PLANNING CONSULTATION RESPONSE

Application No	2025/0259
Proposal	2026 0259 Demolition of Dwelling (Retro) Erection of 1no detached Dwelling with Integral Garages Oak Tree Cottage 1C Chapel Lane Billingley
Address	Oak Tree Cottage 1C Chapel Lane Billingley
Date of Consultation Reply	120526
Consultee	Tony Wiles Senior Conservation Officer

FRONT ELEVATION (N)
SCALE 1:100

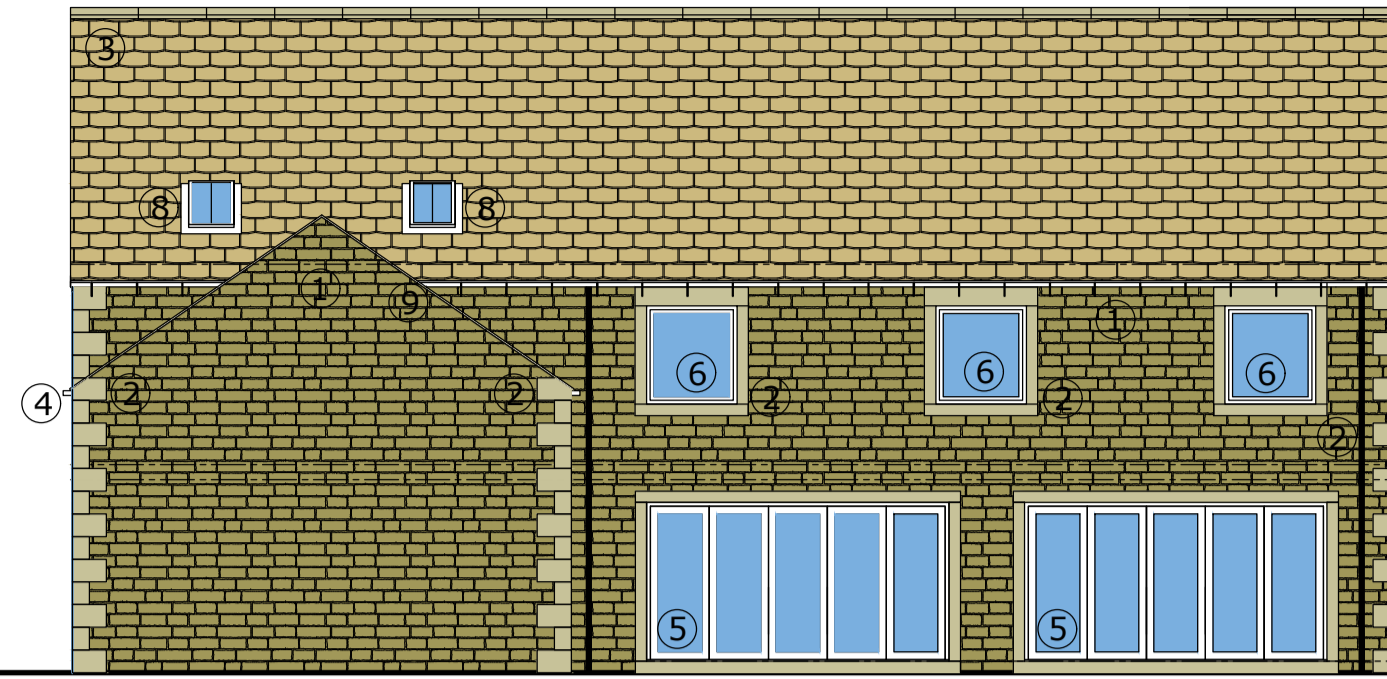
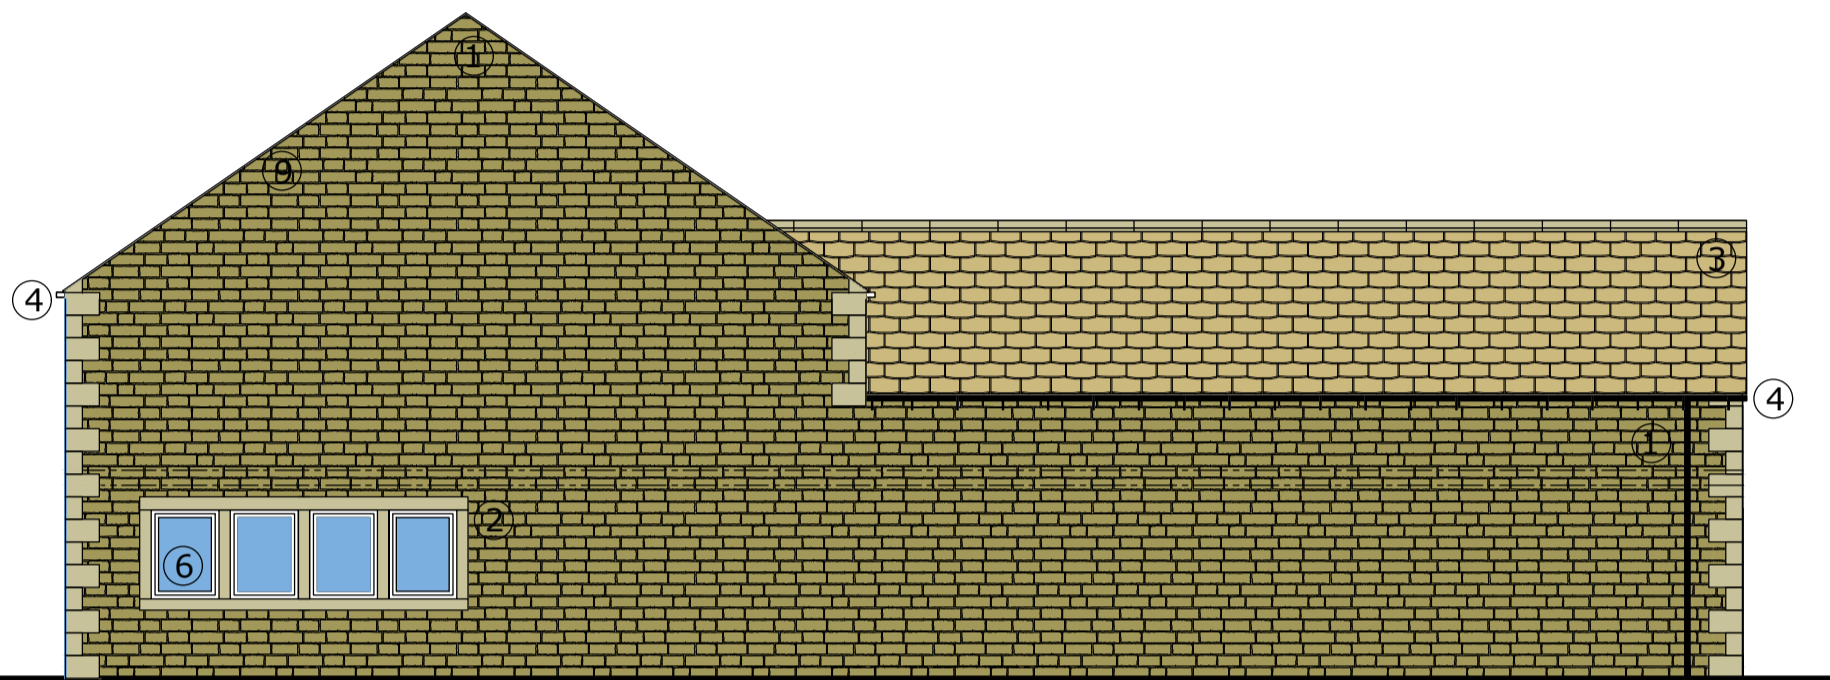
This application (2026/0259) further amends the design approved under 2025/0153. The central full-height front opening has been removed and replaced with a slightly recessed ground-floor entrance, with a mullioned window above separated by masonry. The dwelling now has strongly symmetrical side wings flanking the entrance, each with two four-light mullioned windows at ground-floor level and two at first-floor level. In plan form, the building remains similarly positioned and arranged, but the main house is now deeper on the north-south axis. Additional accommodation is also proposed above the integral garage, served by conservation rooflights. Overall, this results in a larger dwelling than the previous scheme. The roof span is noticeably wider and the roof pitch correspondingly shallower. In general, the building has greater visual mass than the demolished cottage and moves away from an agricultural vernacular towards a more domestic appearance. That said, there are comparable examples within the village, including properties of similar size and scale elsewhere in the conservation area, such as along Back Lane and Barn Owl Close. In my view, the loss of the original cottage fragment remains harmful. However, considered on its own merits, I do not consider this latest redesign to be harmful to the conservation area. The changes newly proposed are relatively restrained and the dwelling will appear similar to the previously approved scheme but marginally larger. The proposed use of high-quality materials helps to offset the increase in scale, which is welcomed. I also consider the increased size unlikely to affect views from the entrance onto Chapel Lane, although it may have a limited additional impact on immediately neighbouring properties. Even so, I consider the redevelopment of the site in this revised form unlikely to harm the character or appearance of the conservation area. Consequently, I would suggest the proposal accords with S.72(1), HE1, and 219.

- The facing stone shall be natural sandstone matching the neighbouring buildings in the conservation area closely in terms of colour, grain size, type of face dressing, and method of coursing. A one-metre-square sample panel of stonework showing the pointing and coursing will be required and the details approved in writing by the local planning authority. The approved panel shall be retained on site until the construction of the building has been completed.
- Pre-commencement / On commencement - a sample of all external materials shall be submitted and approved in writing by the local planning authority.
- Pointing to the external walls shall be in lime mortar, flush to the face of the stone and finished by brushing off to produce a very slightly recessed and rounded joint.
- The roof will be covered by artificial stone slates with matching ridges bed in mortar.

- All windows to be used in the construction of the building shall be constructed in metal / alu PPC. Windows (and doors) shall be mounted in the reveal a minimum of 100mm.
- Window and door heads (and cills), mullions and quoins shall be dressing in natural ashlar sandstone.
- Rooflights to be genuine conservation rooflights, low in profile, vertically emphasised, with black framing and a single vertical divider.
- Gutters shall be ogee in section and black. Gutters, rainwater and downpipes shall be black.
